Amendments to Approved Level II Site Plan – Ocean Gateway Addition

Project: Ocean Gateway Addition

To: Level II Site Plan Staff

Prepared For:	
Consulting Engineer:	
Architect:	ARCHETYPE architects 48 Union Wharf Portland, Maine 04101 (207) 772-6022 Fax (207) 772-4056
Project:	Addition to Ocean Gateway Garage 167 Fore St. Portland, Maine
Revisions:	
Date:	May 26, 2016
Scale:	As Noted
TYP. UPPER FLOOR PLAN	
A1.02

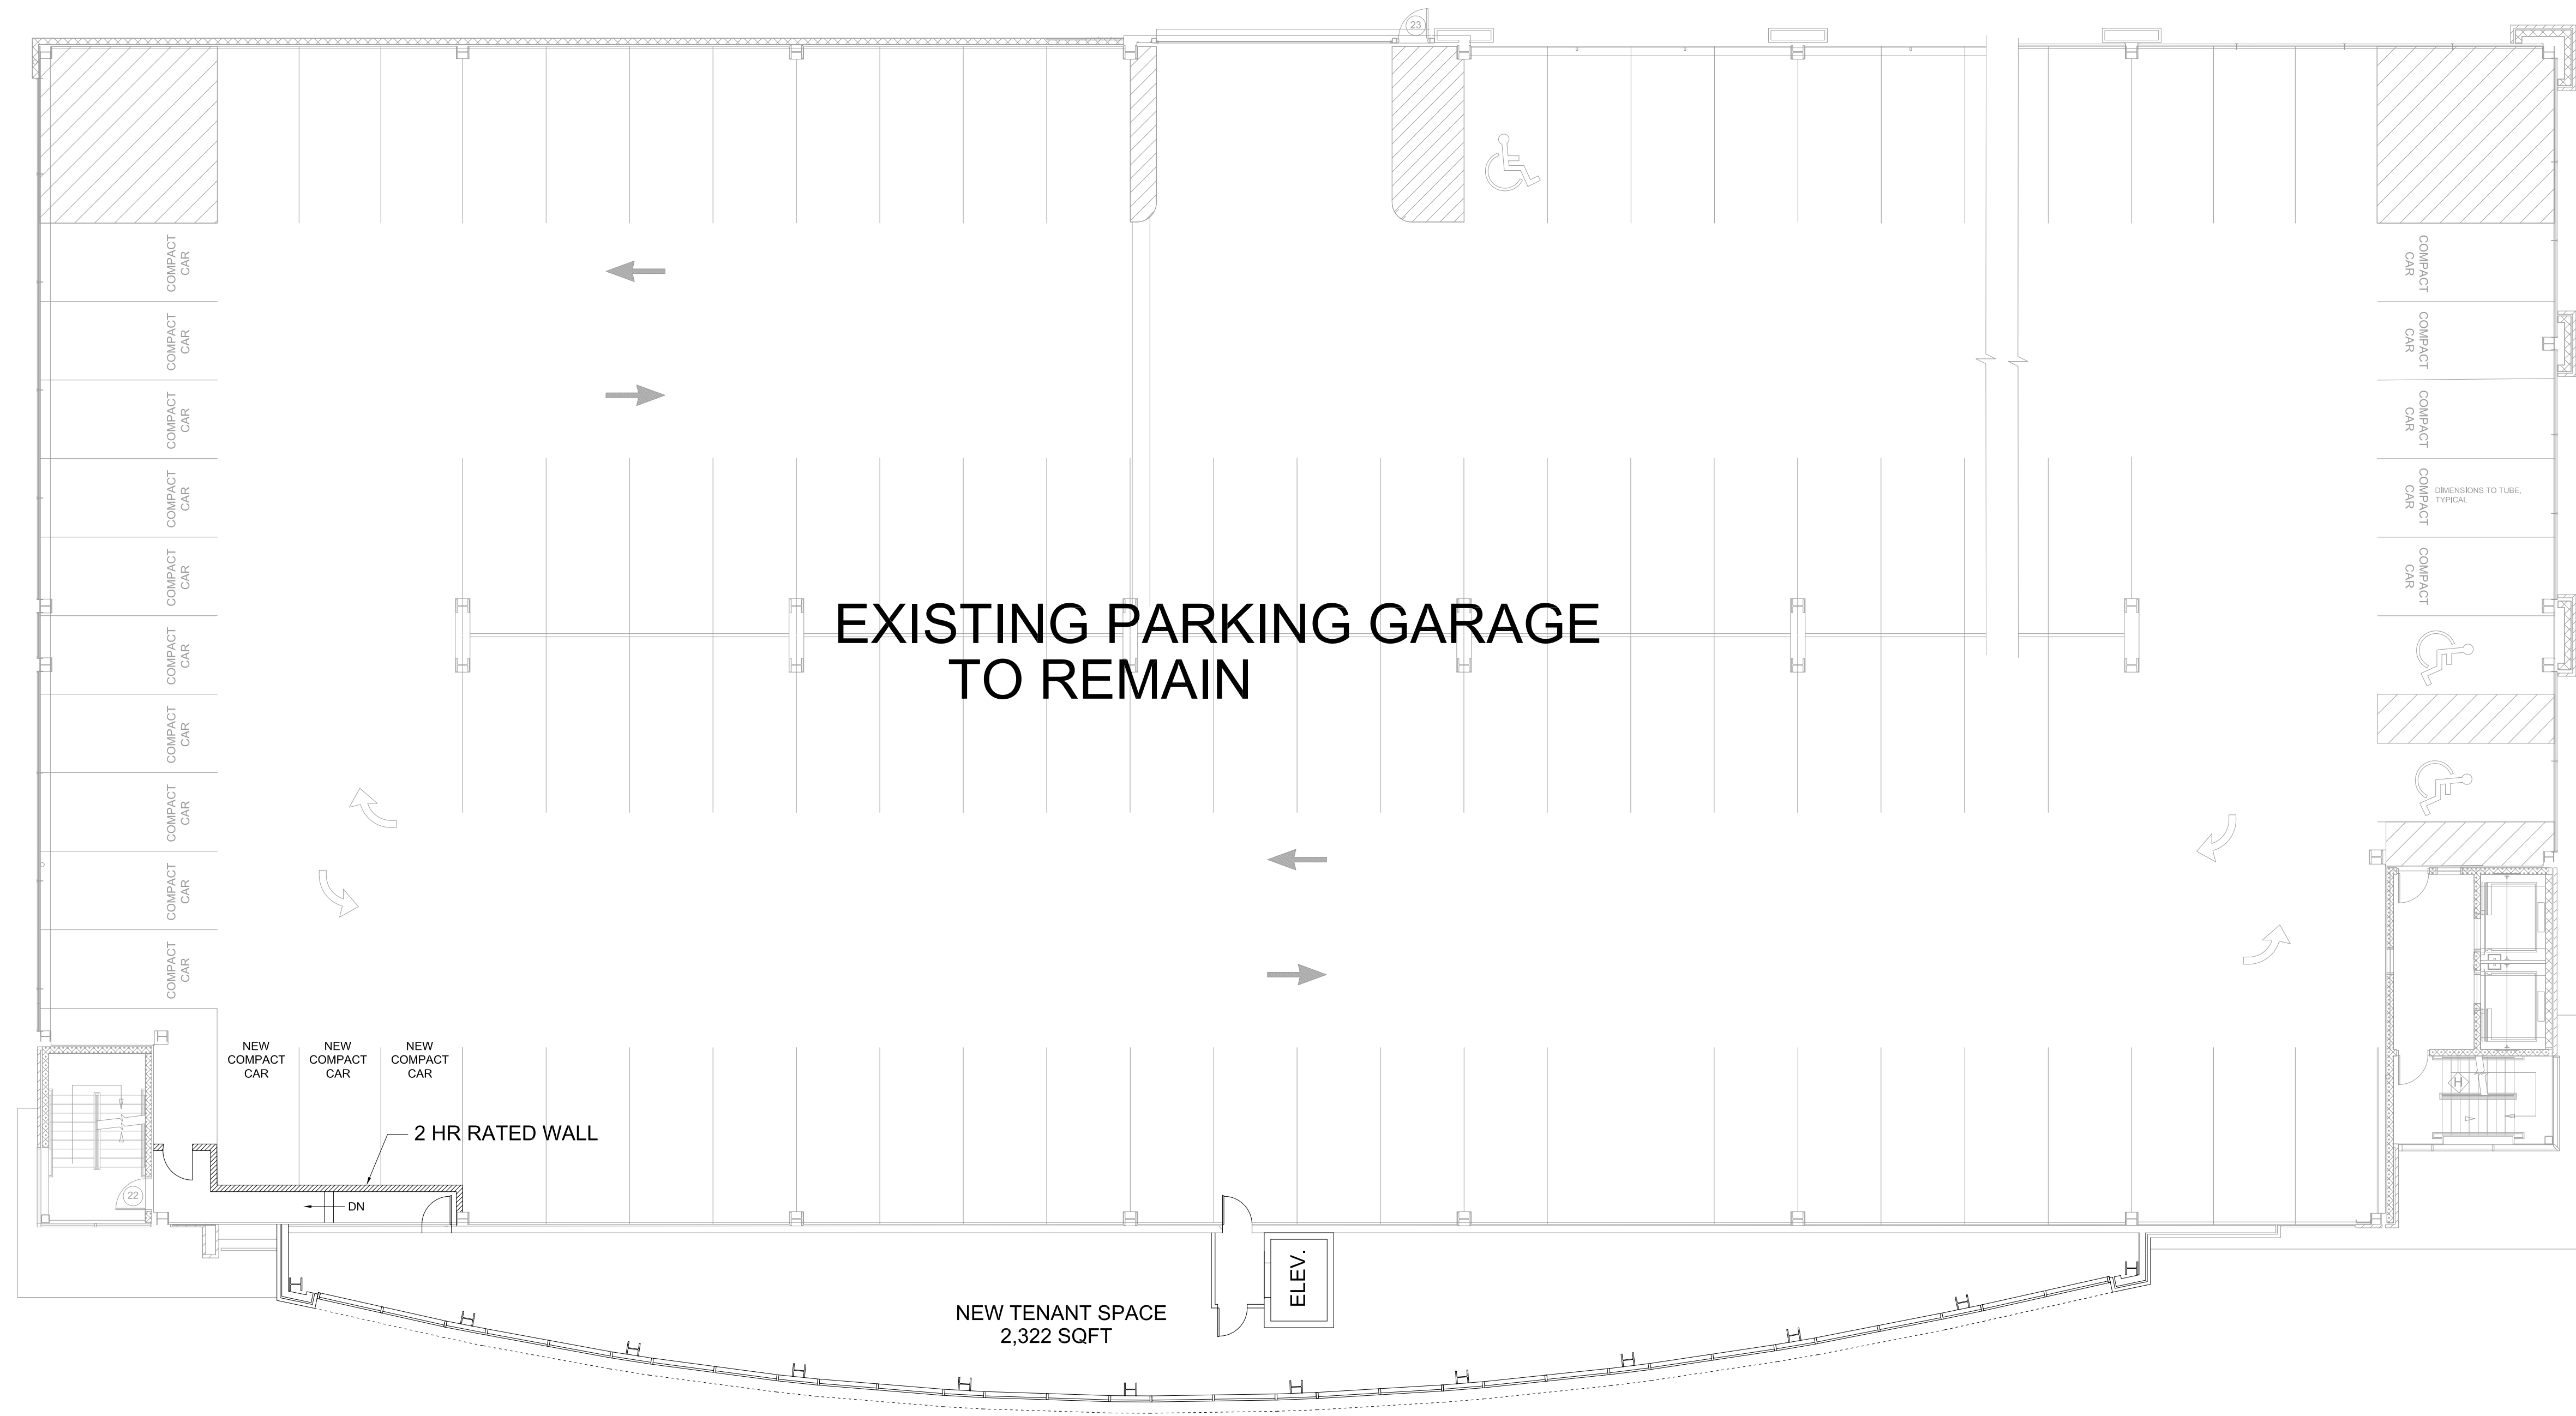
The approved site plan application included the design of the office addition to cantilever over the garage entrance on Fore St. This cantilever was to be wrapped in curtainwall, to match the rest of the addition. Due to structural impact and clearance requirements for drive lanes into existing garage, we have reduced the footprint of the office building by approx. 145 SF per floor (thus reducing the curtainwall) at the south west corner of the addition. We will no longer be cantilevering over the garage entrance, but instead will line up with the end wall of the existing retail space.

(These changes can be seen on floor plans A1.00 – A1.06 and building elevation on A2.01)

Due to the reduction in footprint of the addition, we have extended the length of the rated corridor in the garage, to maintain a rated corridor access from the addition to the existing exit stair of the garage.

(These changes can be seen on floor plans A1.01 – A1.06)

The original approved design included the end wall (southwest corner of addition) to be constructed of a metal stud wall to be wrapped in a metal panel system. We have changed this end wall, approx. 10'-0" in length, to a curtainwall system (to match front façade) to open up the space back to the city and create a stronger visual connection.

(These changes can be seen on floor plans A1.01-A1.06)
